4-10-19

Hydrology Comments on Wall Permit 201400097

COVERED WAGON SUBDIVISION
GRADING AND DRAINAGE PLAN
GRADING DETAILS
INTERSECTION OF: LANIER DRIVE /
COVERED WAGON AVENUE
LOTS 15, 16, 17, 18, 19, 20, 21, 44, & 45

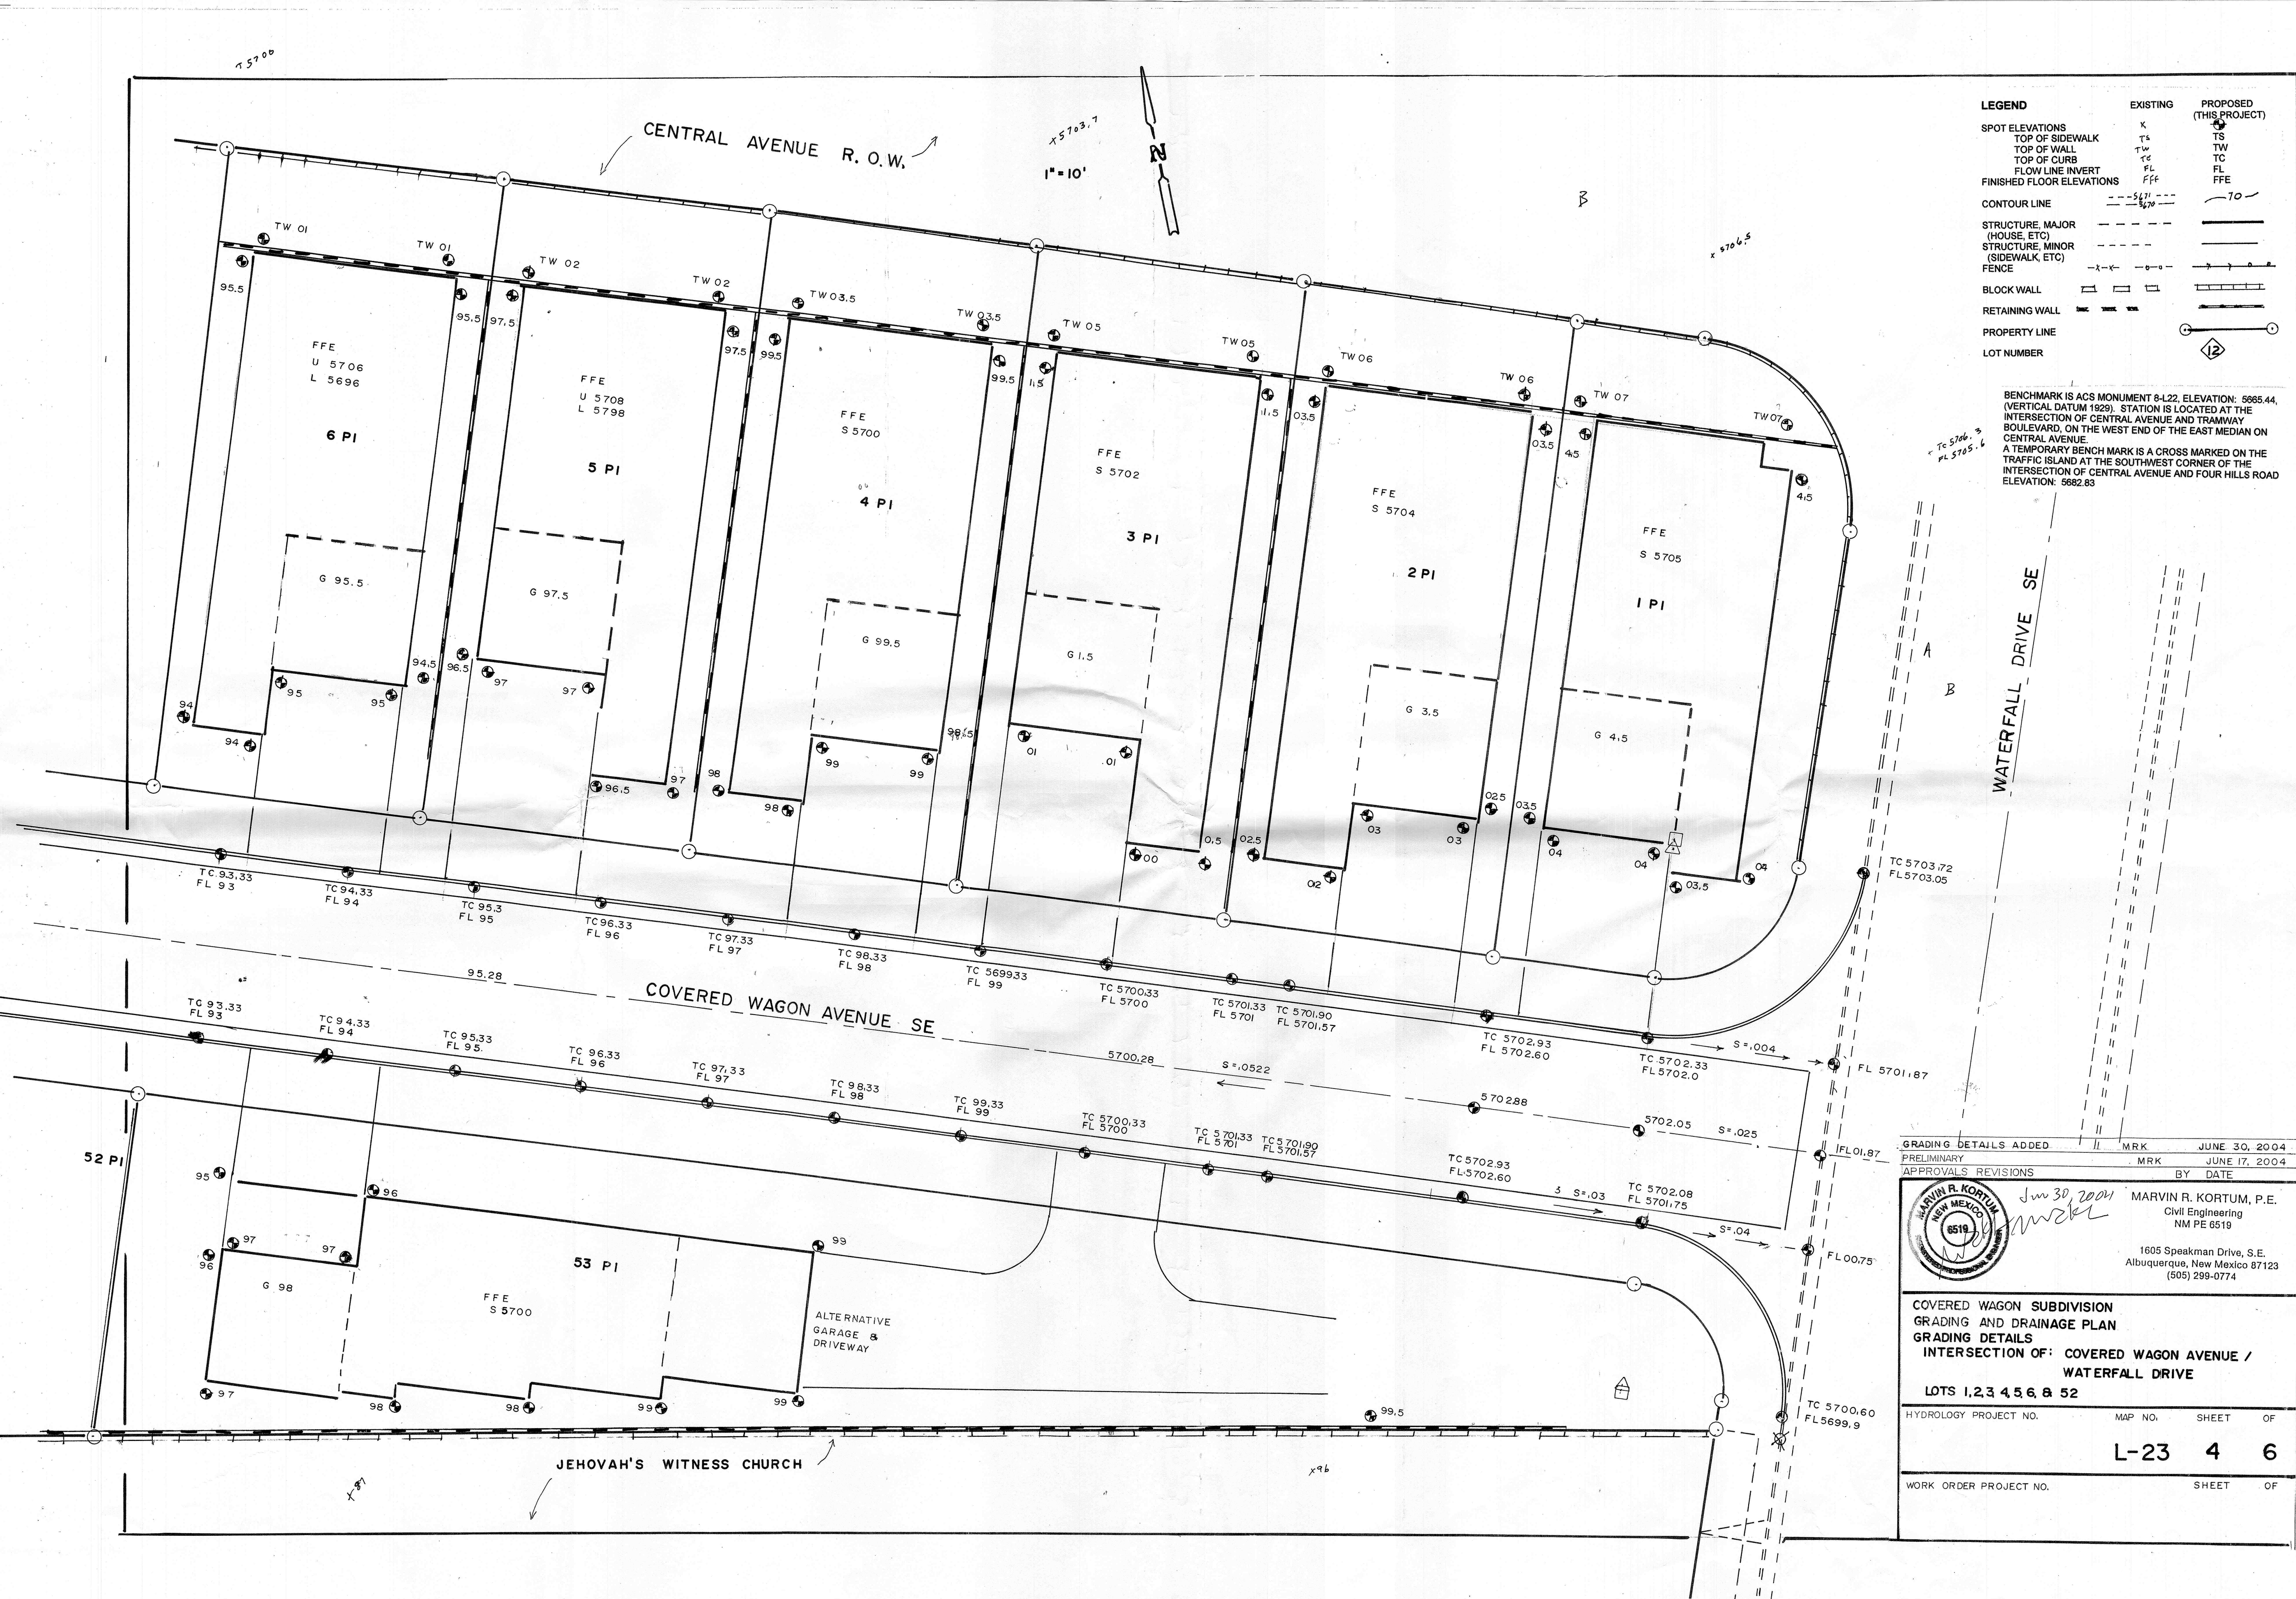
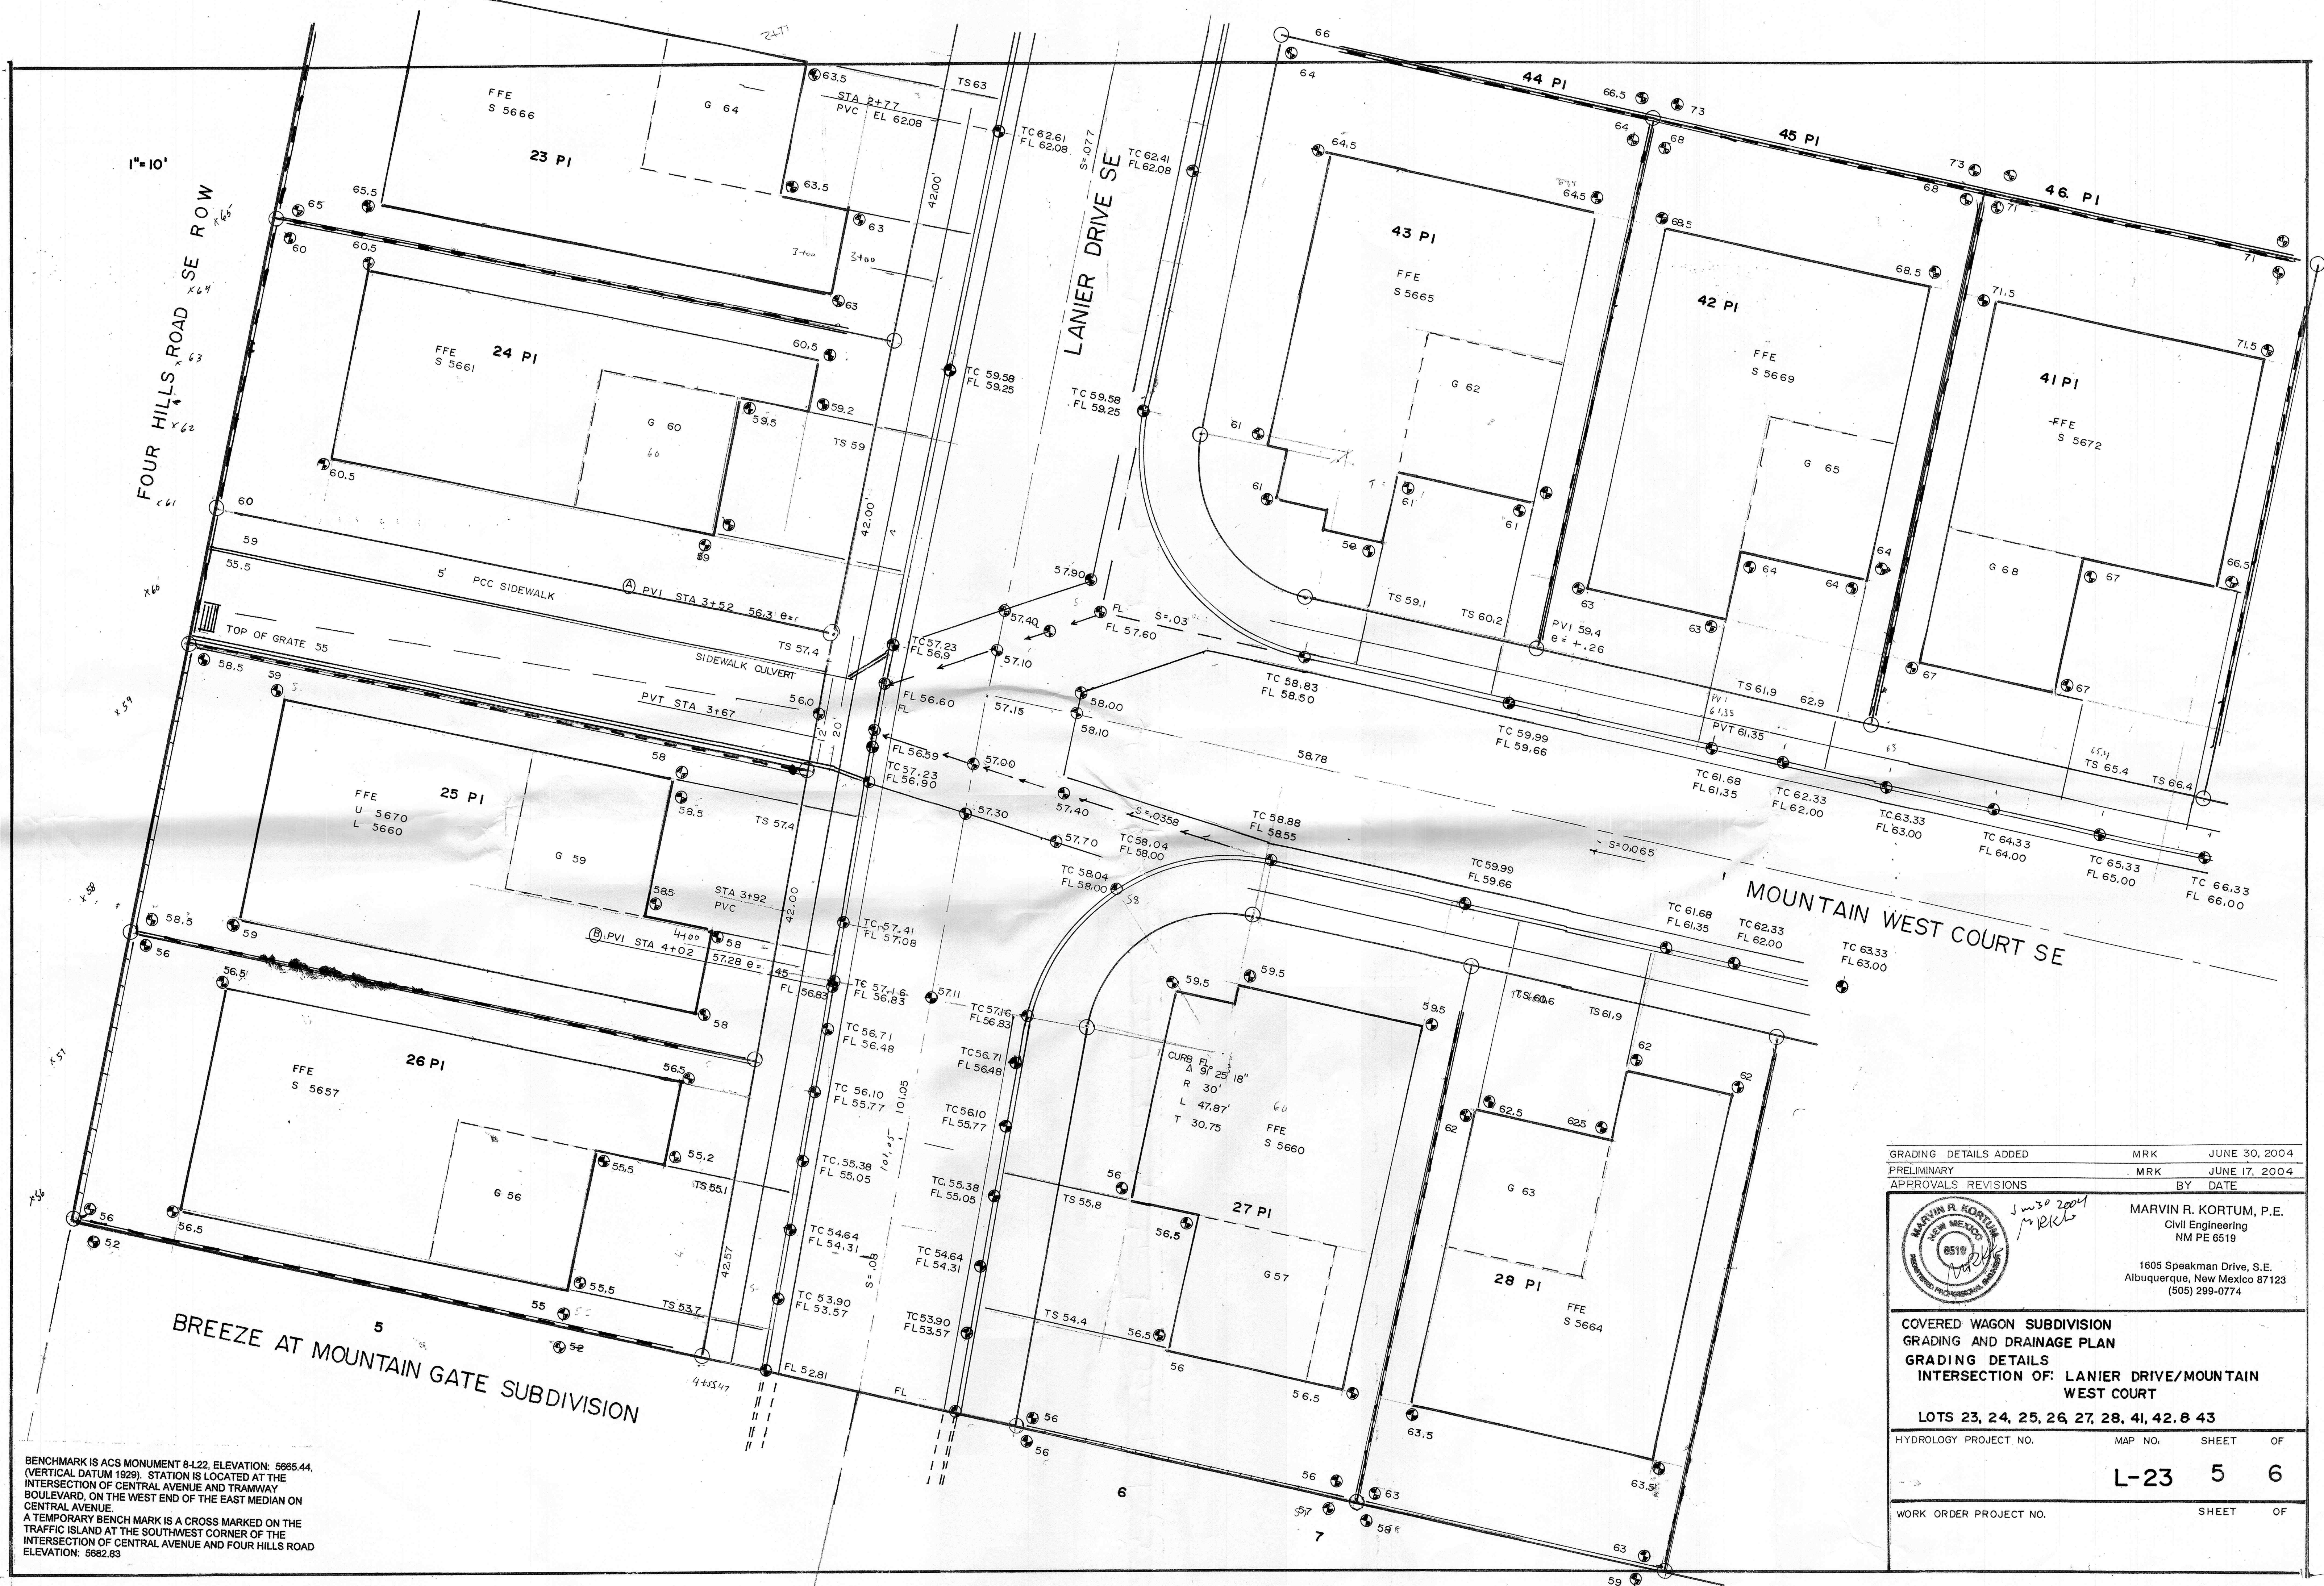
1. Include all property lines and the Public Utility Easement on a scaled site plan. The PUE is 7 feet wide, south of the north property line.
2. The retaining wall and the "if required" wall shown above the retaining wall should be located outside the PUE and ROW.
3. Tension mats should not extend into the PUE or ROW.
4. It is not clear if the proposed wall is the same height as shown on the approved grading plan. The site plan will help with this determination.
5. Show location of retaining wall on the scaled site plan.
6. Include a copy of the approved grading plan, Marvin Kortum 6-17-04 and 6-30-04, in the permit set or a revised grading plan.
